RE: 3/2025/0417, 3/2025/0418 (JCNAS 209233) | Old Courthouse, Gisburn Road, Bolton by Bowland, Lancashire, BB7 4NP (Grade II, 1859 with earlier remains). Application for internal and external alterations, Air Source Heat Pumps and new garage.

Thank you for consulting the Victorian Society on this application. Having considered the proposal carefully, we **raise concerns** to these plans in their current form.

Section Through Hallway / Landing (Looking Towards New Staircase).  
Scale 1:25

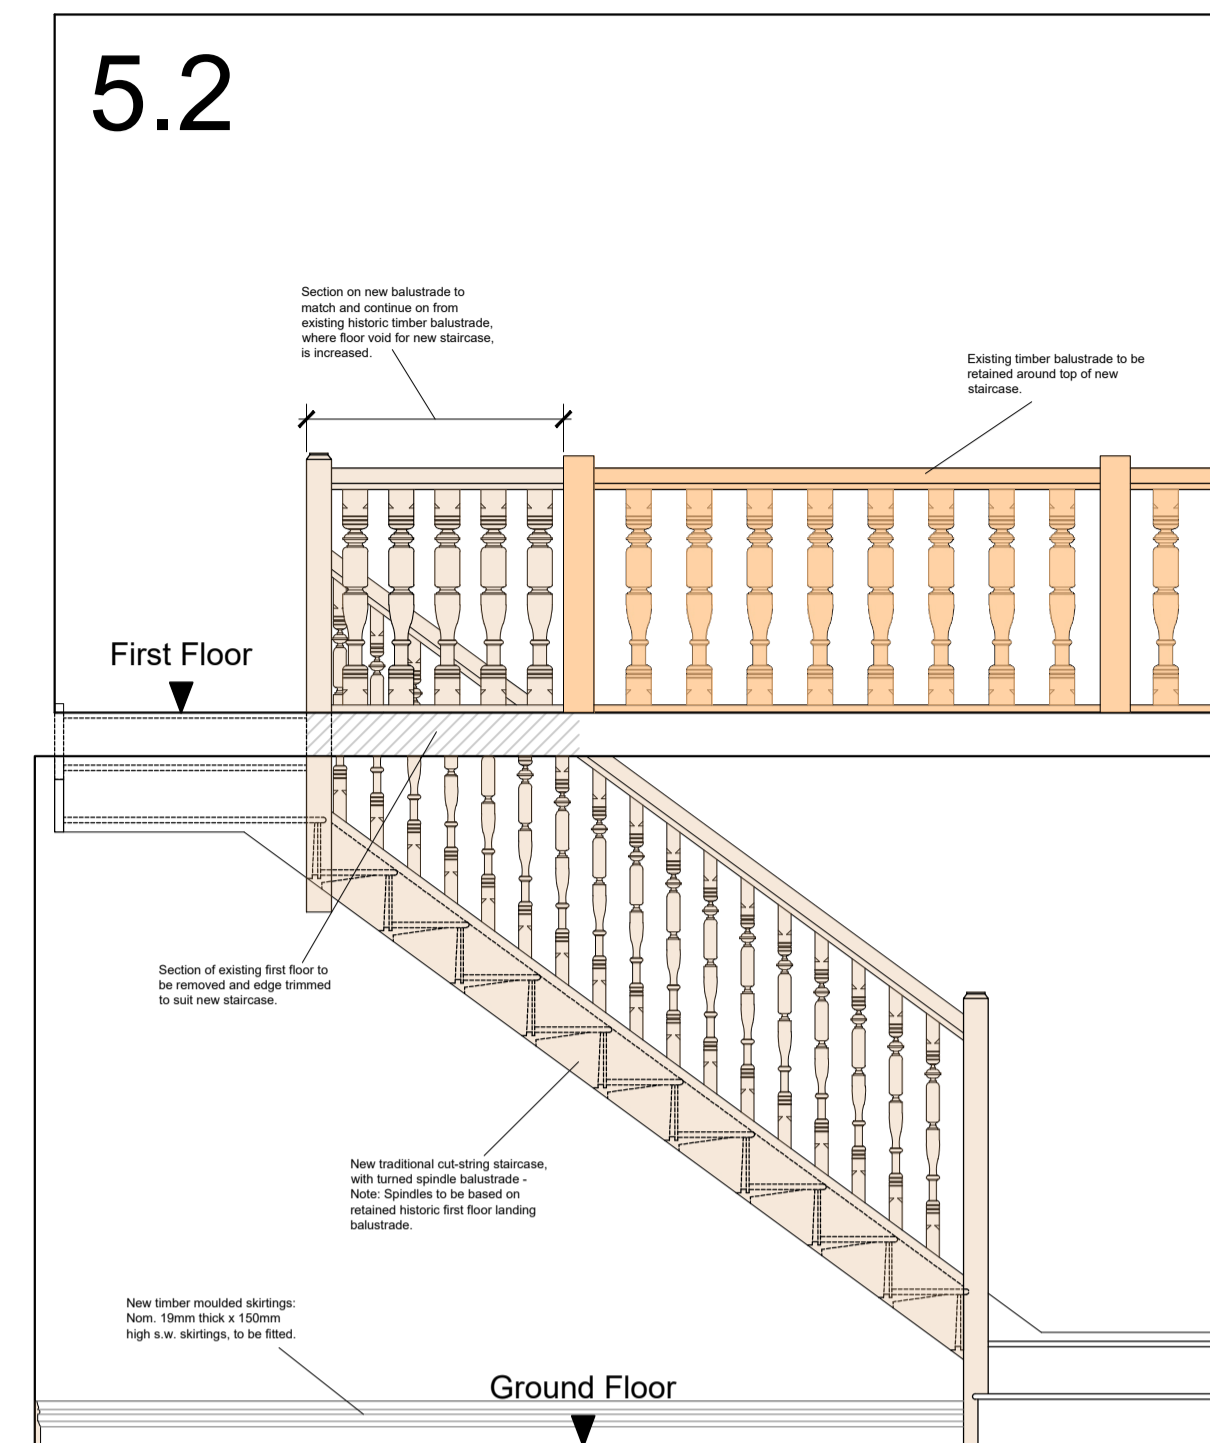
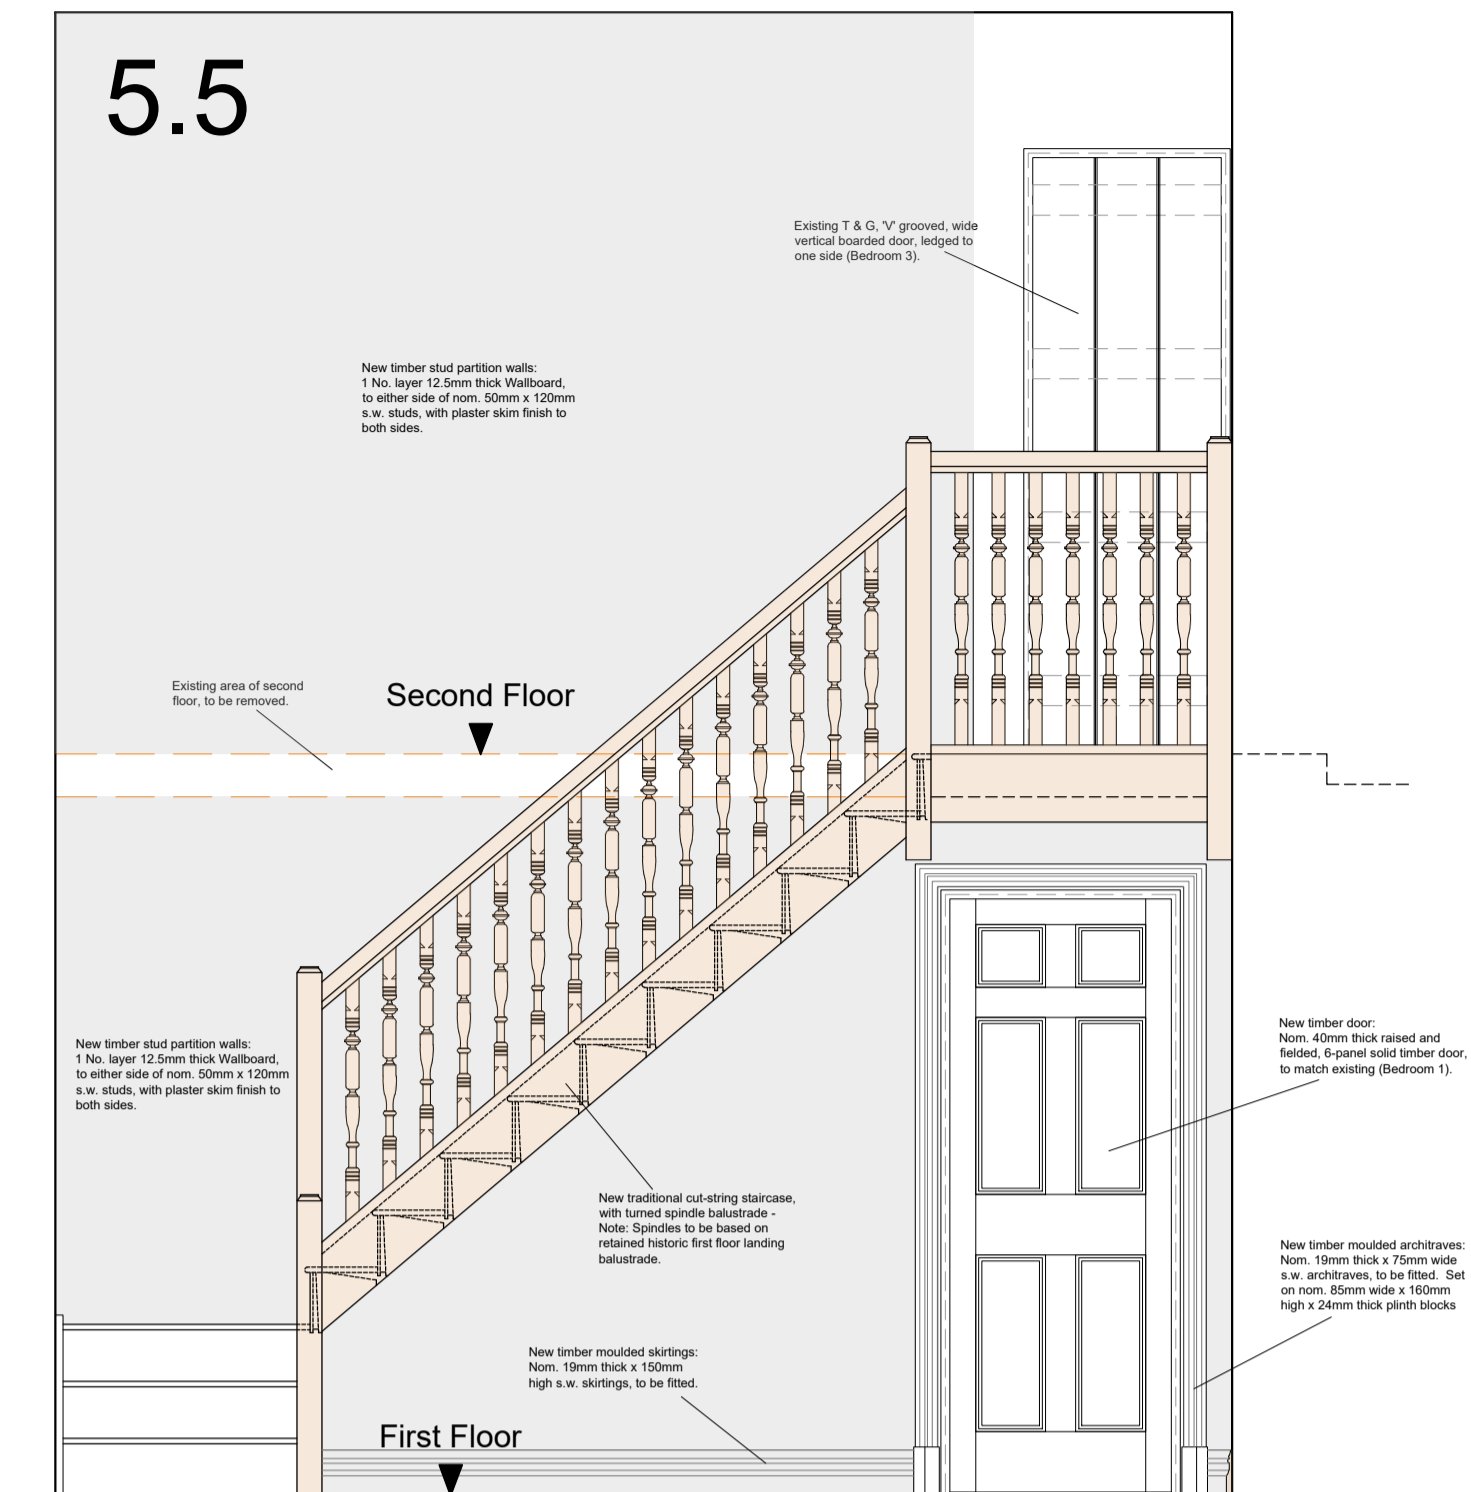
As highlighted by Historic Buildings and Places, the staircase has not received ample assessment in the HIA, and this need for '*clear and convincing justification*' is a key section within the National Planning Policy Framework (2024, paras. 212-215). Secondly, we are concerned that the impact of the location of the air source heat pumps and their effect on historic fabric has not been effectively assessed and would benefit from further discussion.
